6 December 2011

Sydney
WATER

MP10_0179 Project Application for Graythwaite Rehabilitation Centre, Ryde Hospital

Sheet Subject
SITEWORKS PLAN

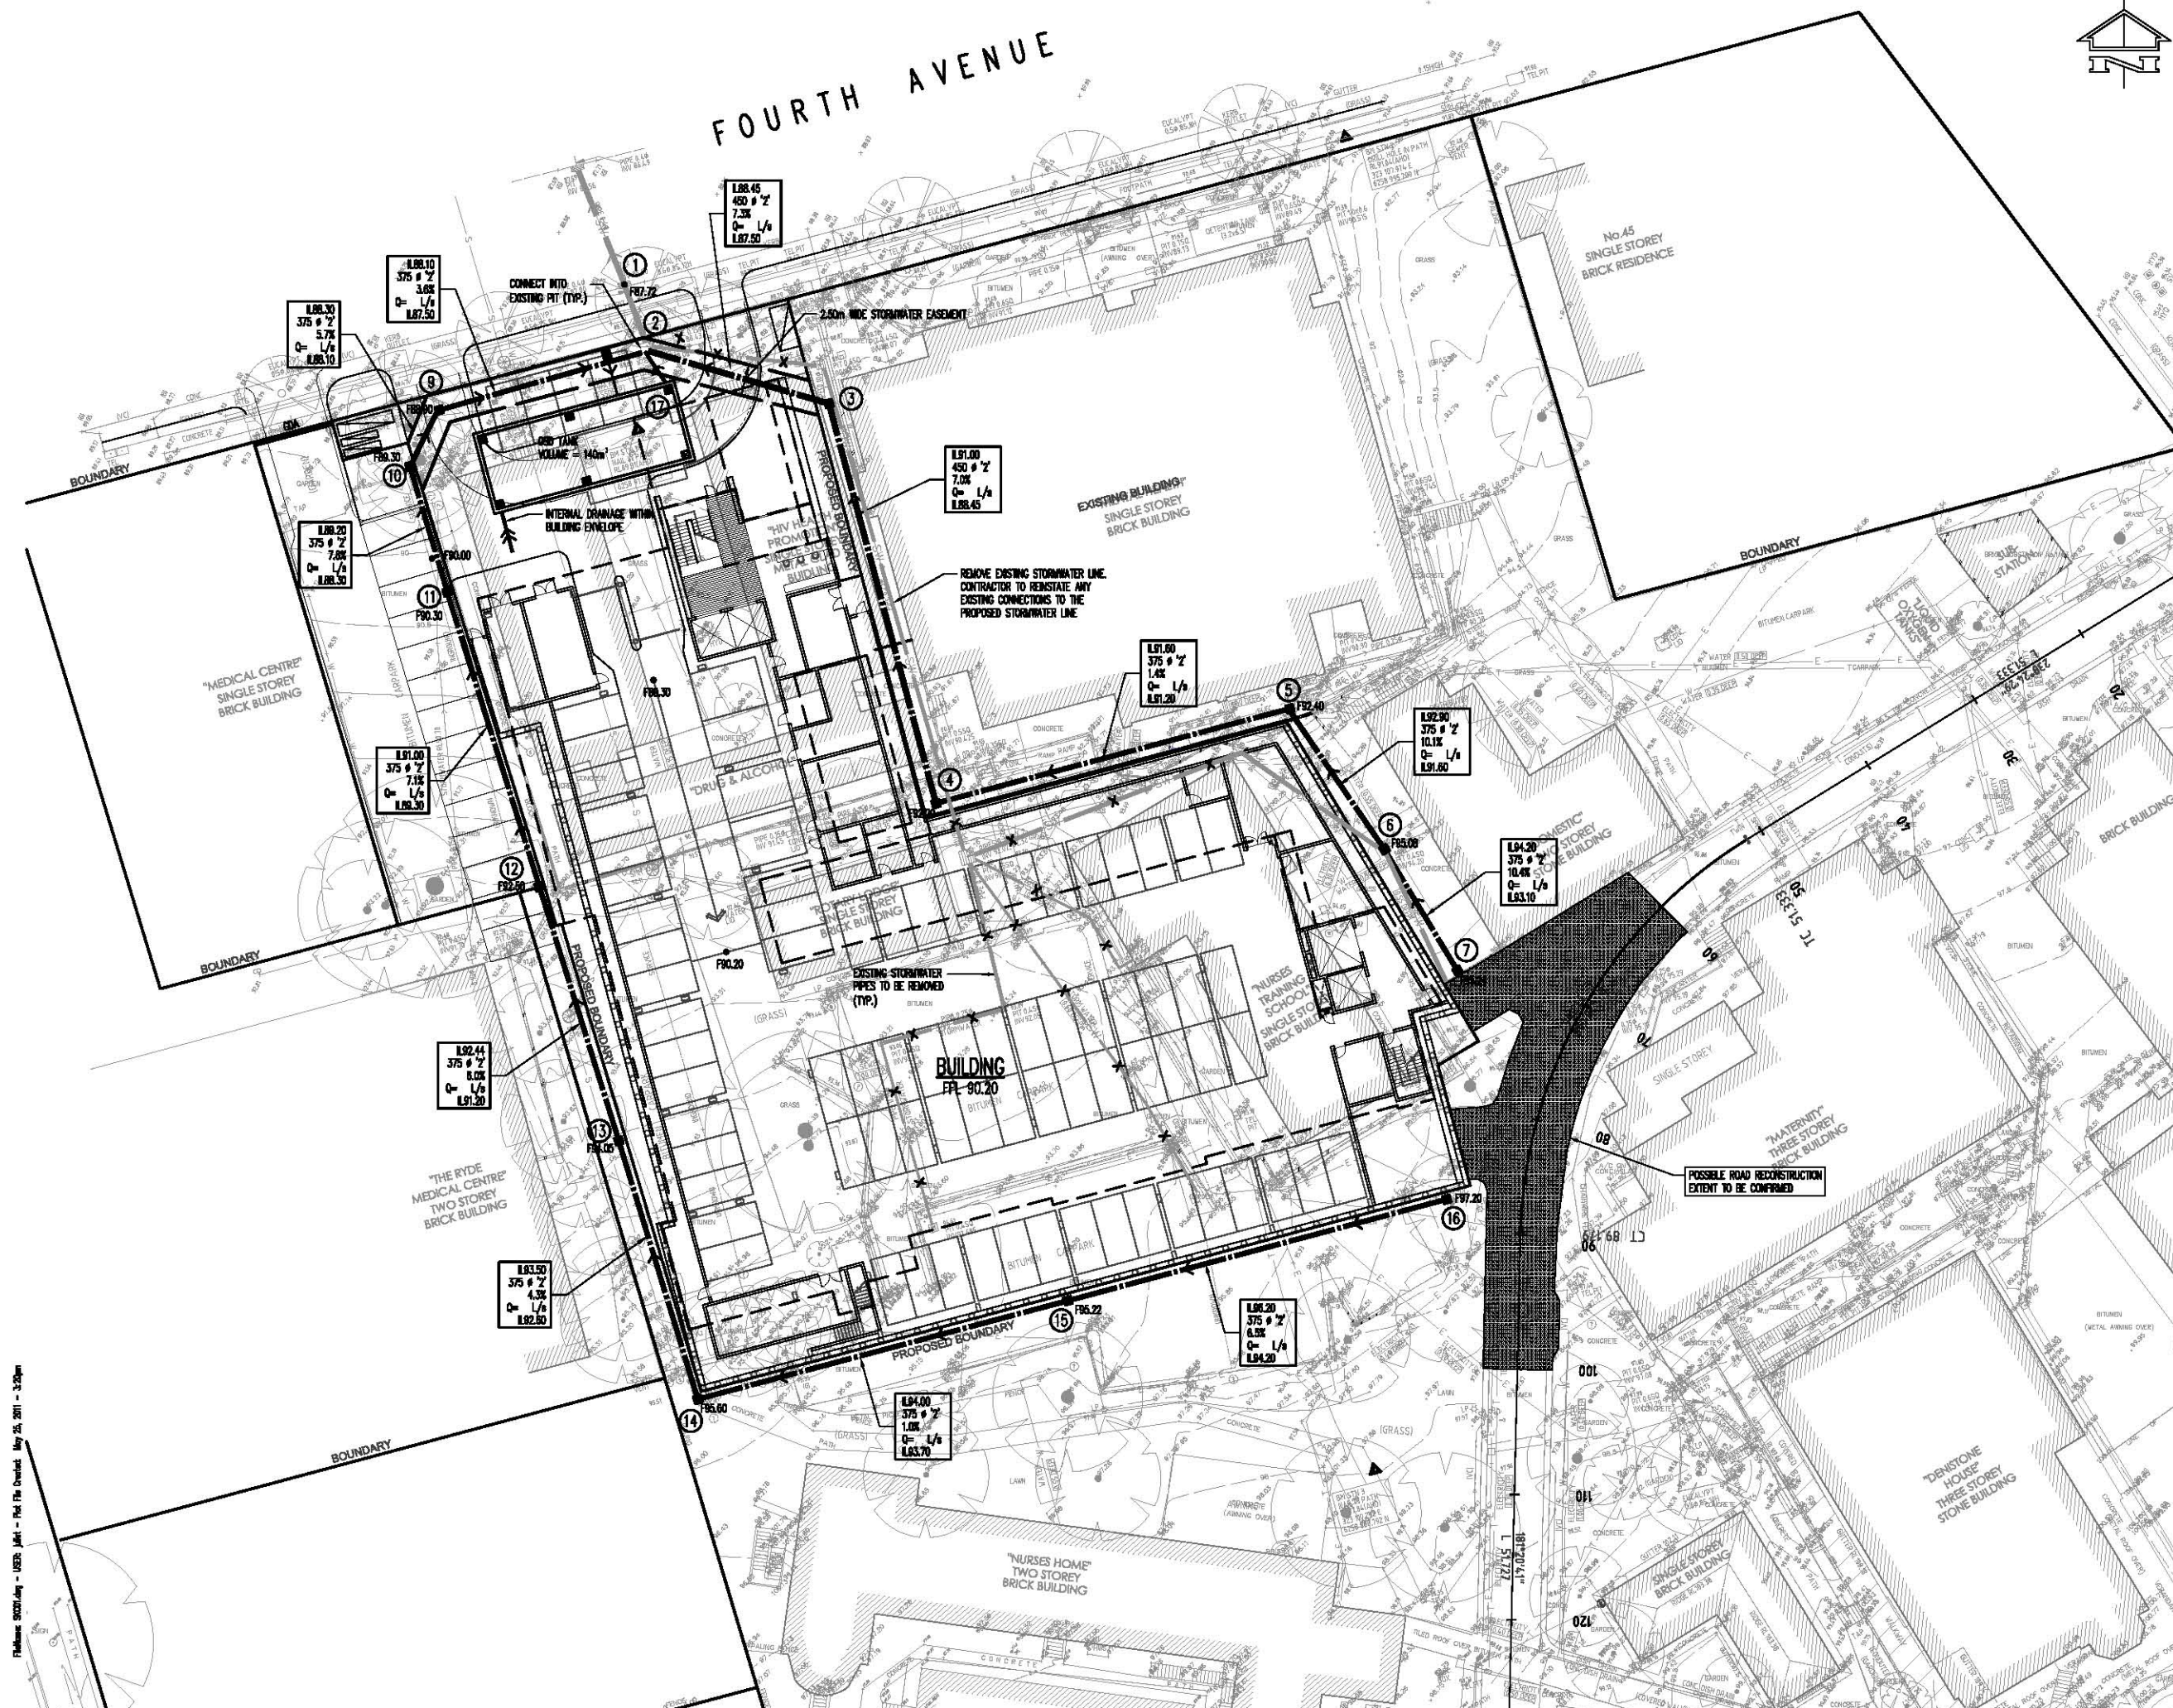
The 100mm drinking water main fronting the proposed development in Fourth Avenue does not comply with the Water Supply Code of Australia (Sydney Water Edition – WSA 03-2002) requirement for minimum sized mains for the scope of development.

The drinking water main needs to be upsized to a 150mm main from point 'A' to point 'B' ('B' is 2 metres past the point of connection) as seen in the plan below. All adjusted drinking water mains are to be re-laid at standard depth for that main sizing and where possible in Sydney Water's allocations. Any fittings affected by road alterations are to be adjusted to the designed finished surface level.

The proposed development conflicts with the location of this 225mm wastewater main. A wastewater deviation may be required.
